## READ PARISH COUNCIL

Planning Application No: 3/201/0857

Proposal: Application for Outline Planning Permission for two dwellings including access (all other matters reserved)

Location: Lowood, Whins Lane, Read BB12 7RB

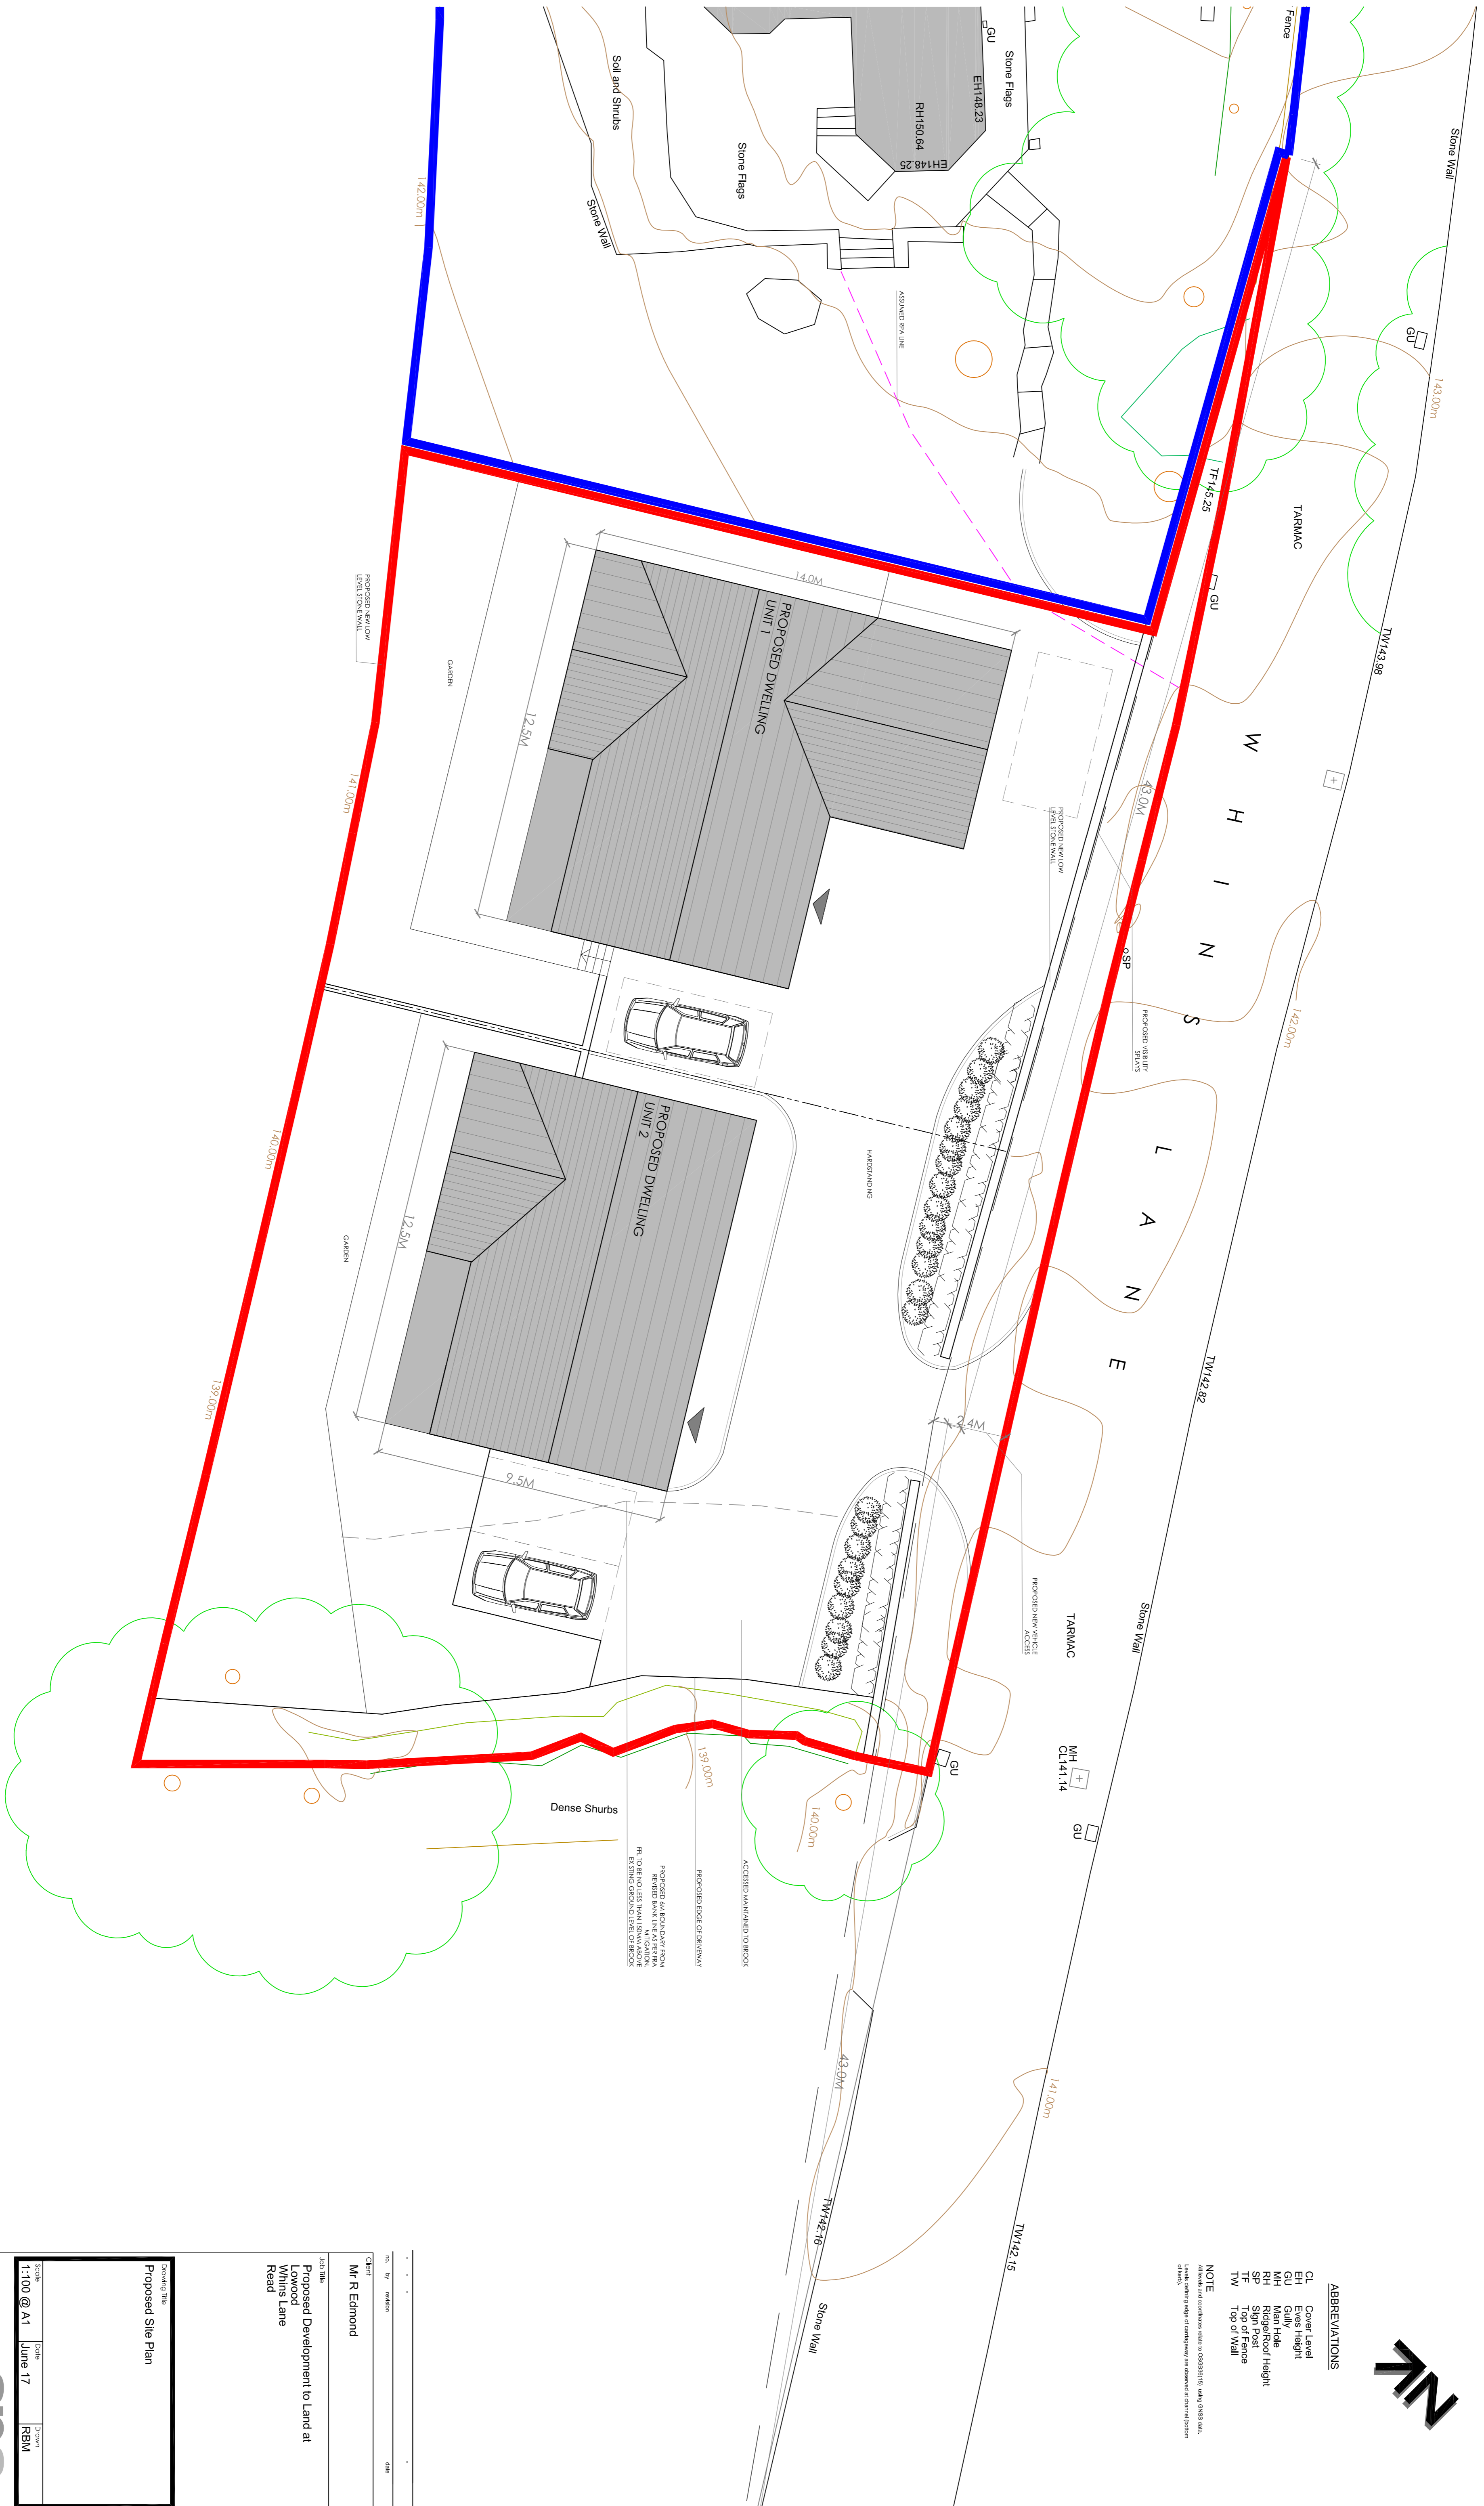
Parish Council object to this application as the location is outside the settlement boundary and the submitted plan is for both properties to share an access on to Whins Lane where adequate sightlines cannot be achieved and highway safety would be compromised.
